Rezoning Transportation Analysis

Petition Number: 2025-088

Date	Description
8-28-25	First Review (KC)

TECHNICAL DATA
SHEET

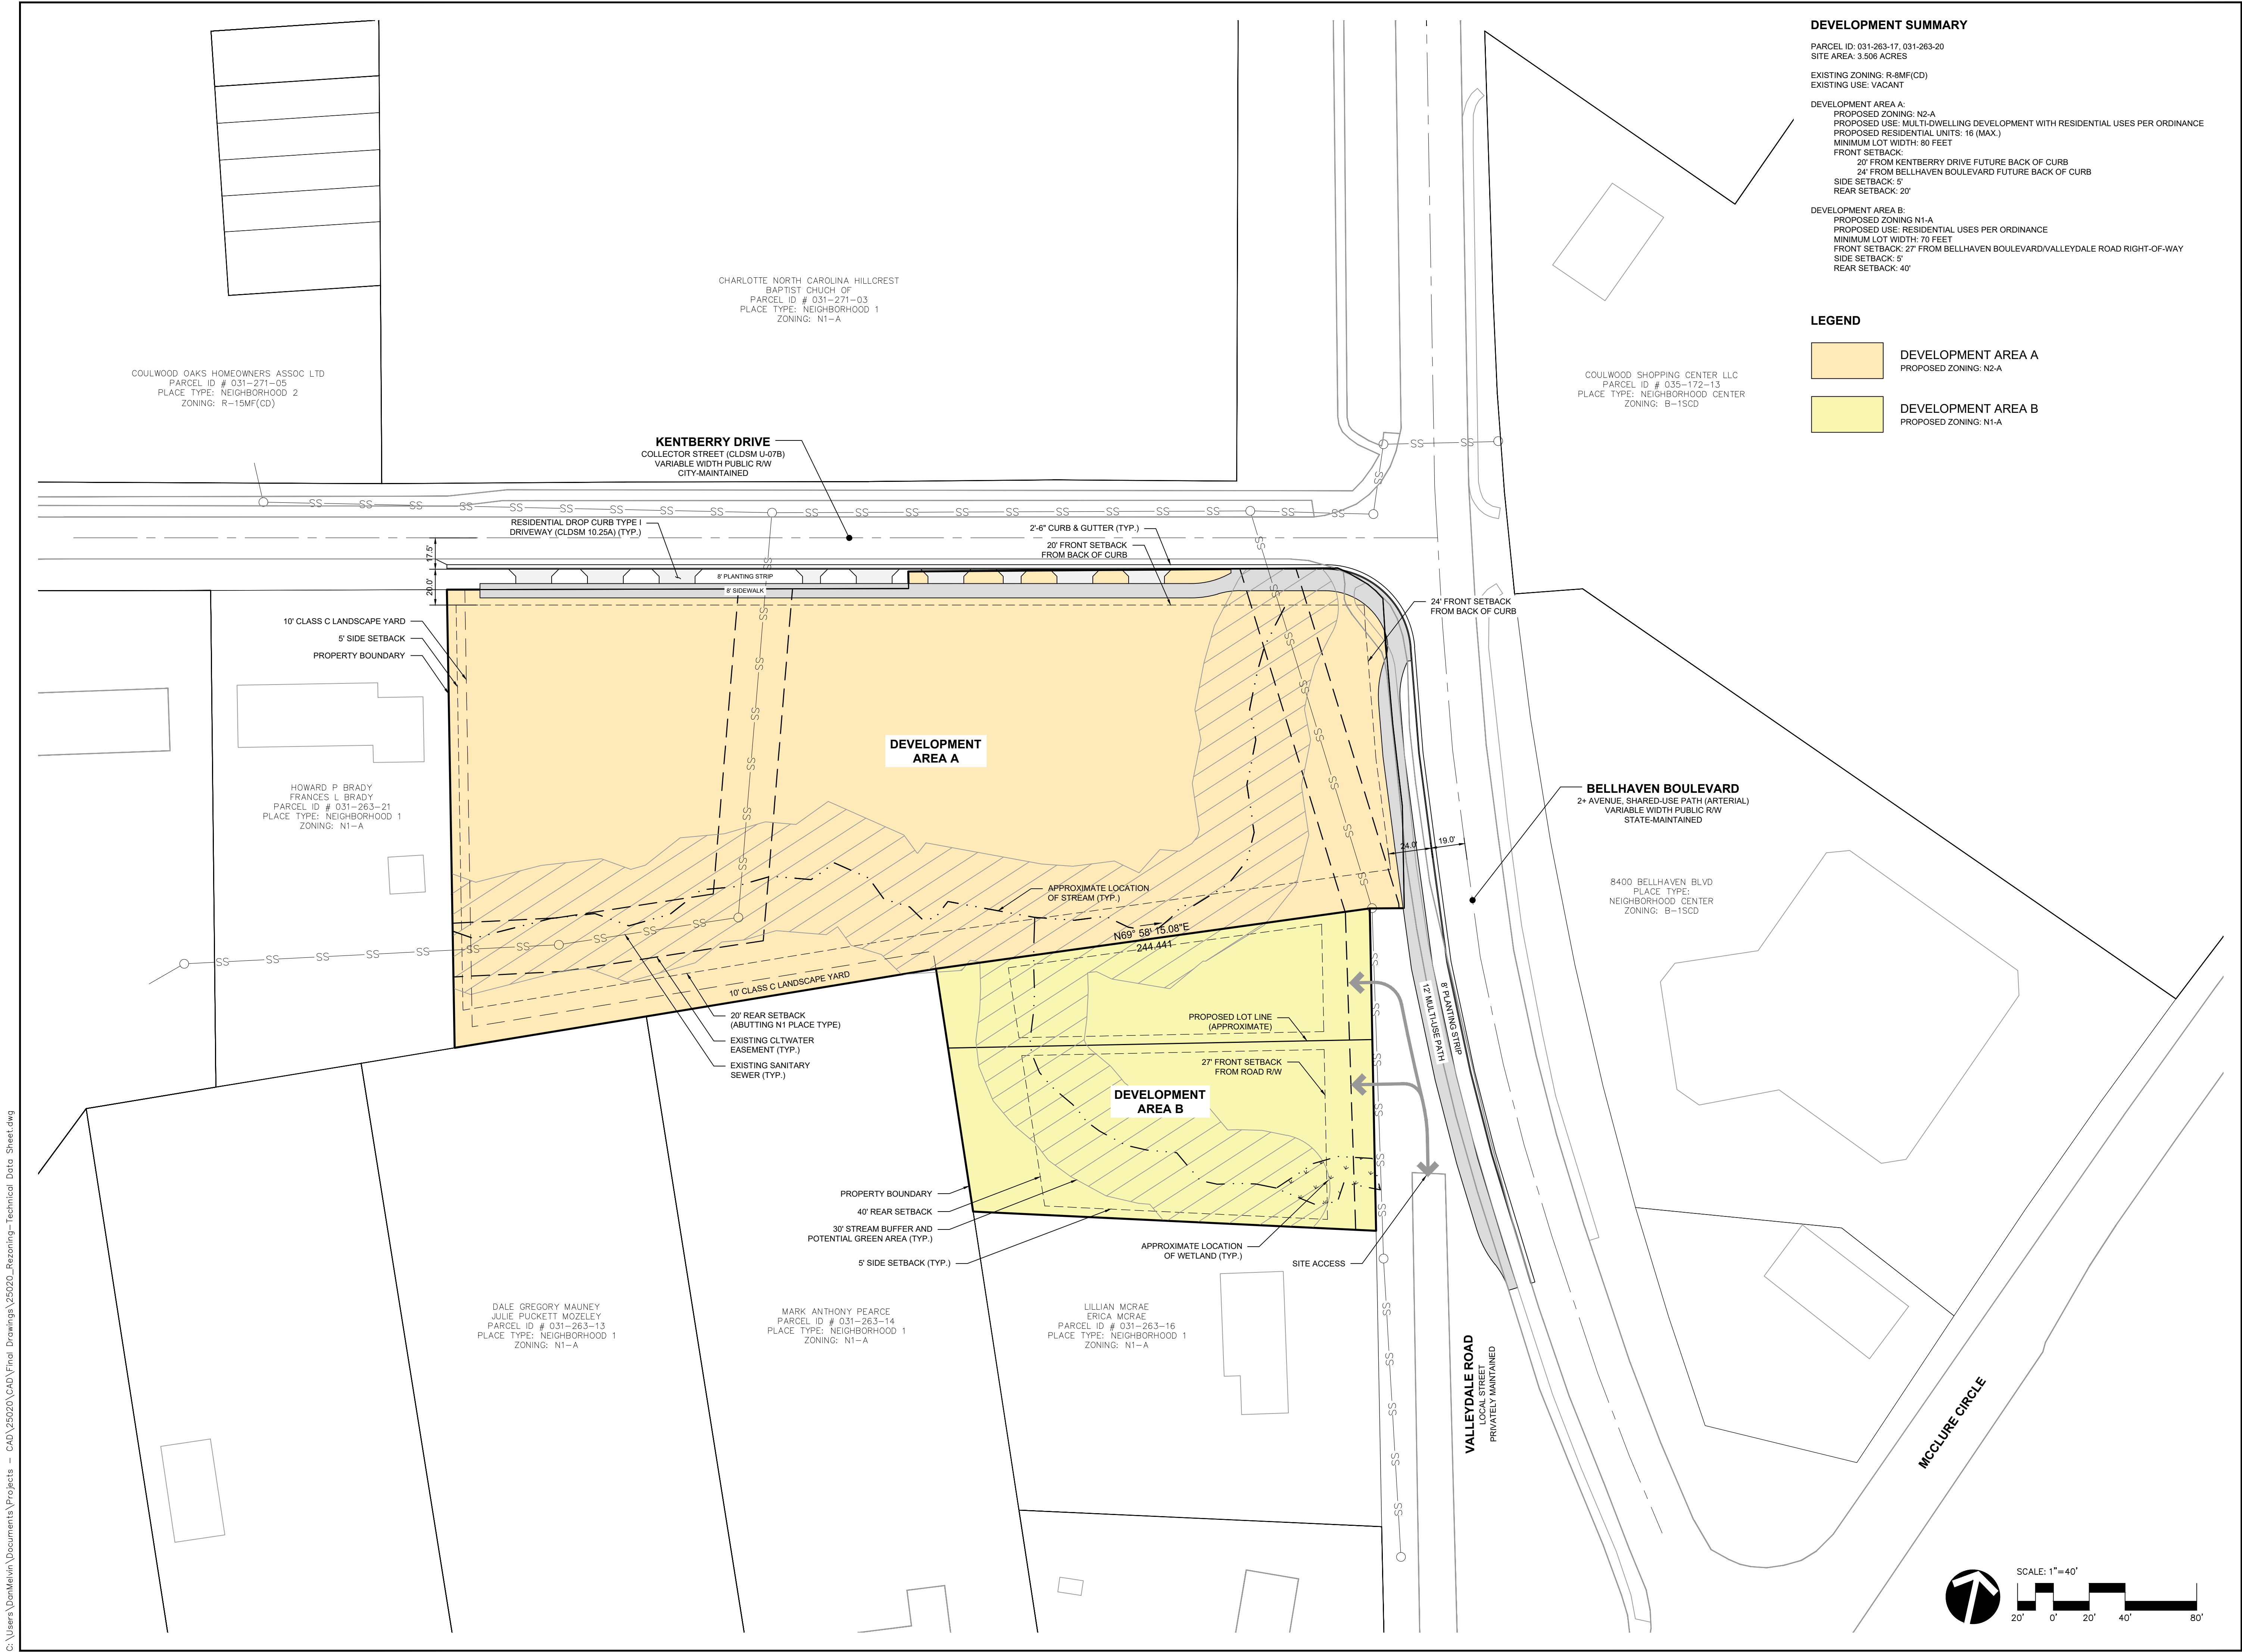
- a. **Bellhaven Boulevard:** Location of future curb and gutter is to be located 19' from centerline.

Label and dimension the curb and gutter from the centerline for each road on the site plan.

- b. **Kentberry Drive:** Location of future curb and gutter is to be located 17.5' from centerline.

Label and dimension the curb and gutter from the centerline for each road on the site plan.

3. Revise site plan and conditional note(s) to commit to dedicate 33.5' of right-of-way from the road centerline along Kentberry Drive. The site plan shall label and dimension the right-of-way from the road centerline.
4. Revise site plan and conditional note(s) to commit to construct bicycle facilities by installing a 12' multi-use path along Bellhaven Boulevard in accordance with the council-adopted Charlotte Streets Map. Multi-use paths maintained by the City shall meet ADA/PROWAG requirements.

SCHEMATIC
SITE PLAN

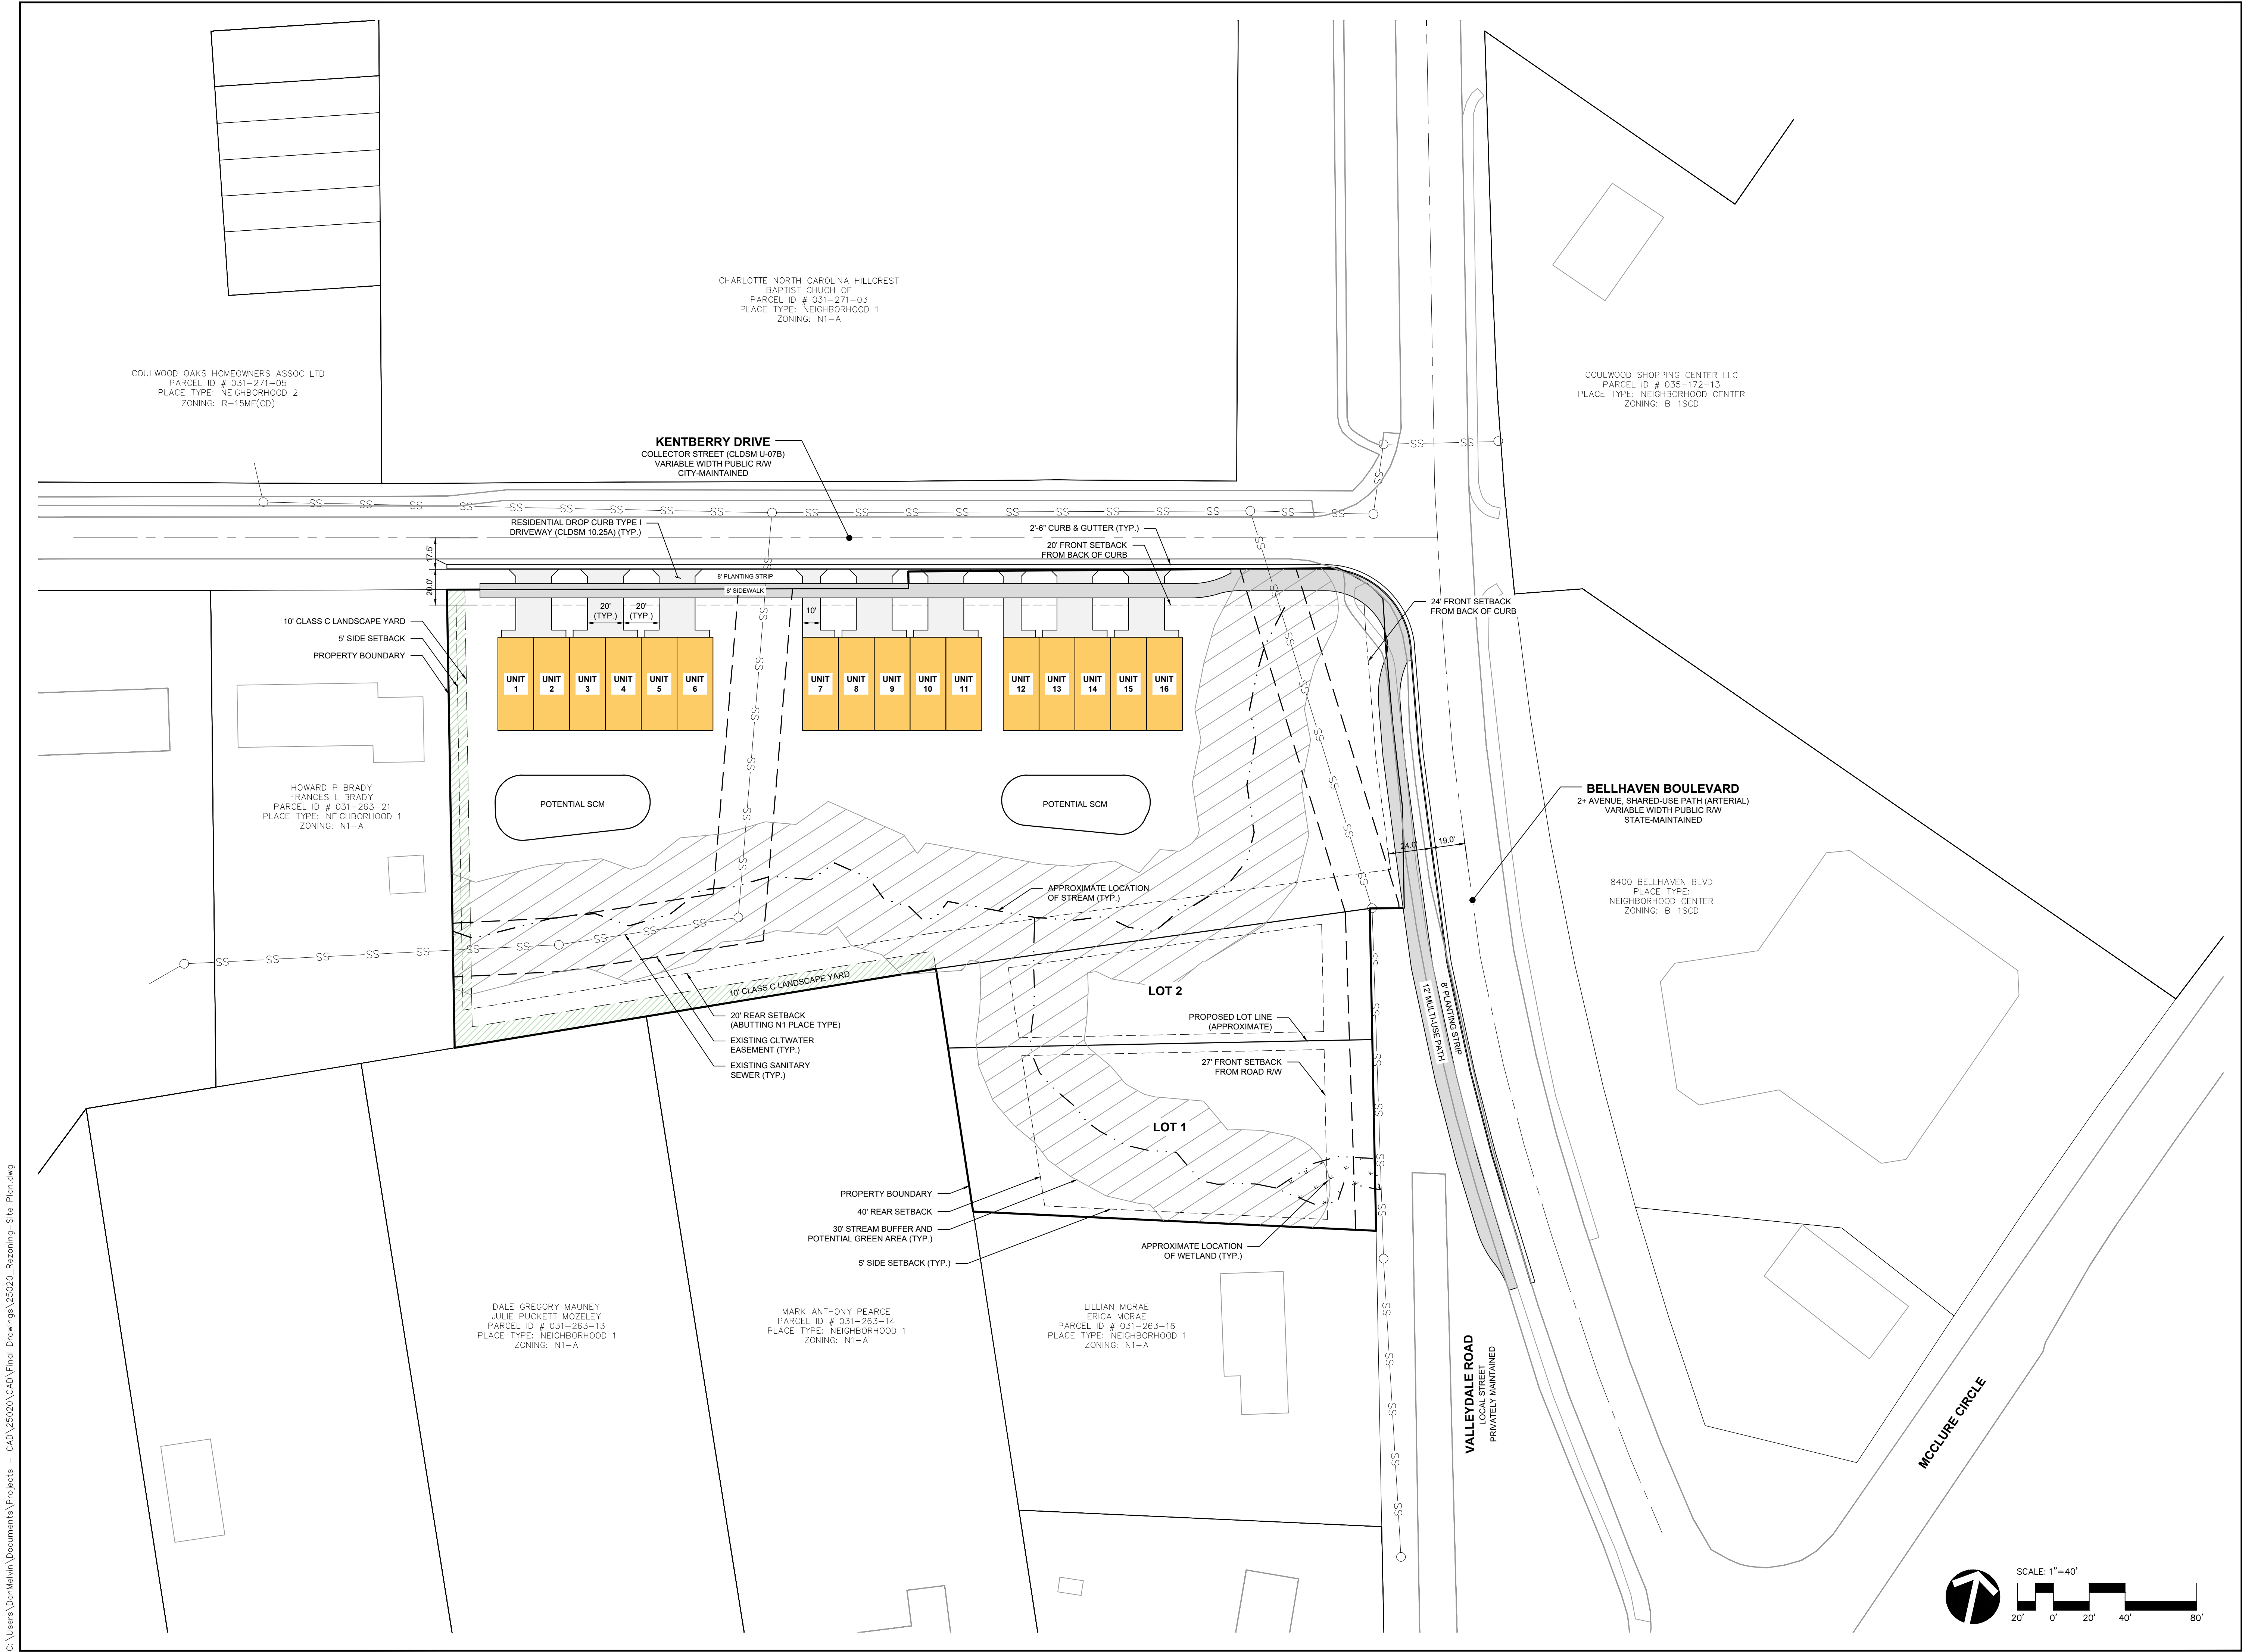
7. Revise site plan and conditional notes to have units access internal to site with a private alley. (i.e. closer to your original submitted site plan. (See below.)

11. Revise site plans and conditional notes to have a shared access for Lot 1 and Lot 2. (see snip below)

Also, install guardrail in-between Valley Dale Road and the proposed shared use path. CDOT and NCDOT has safety concerns about the access's vicinity to the 12' Shared Use Path.
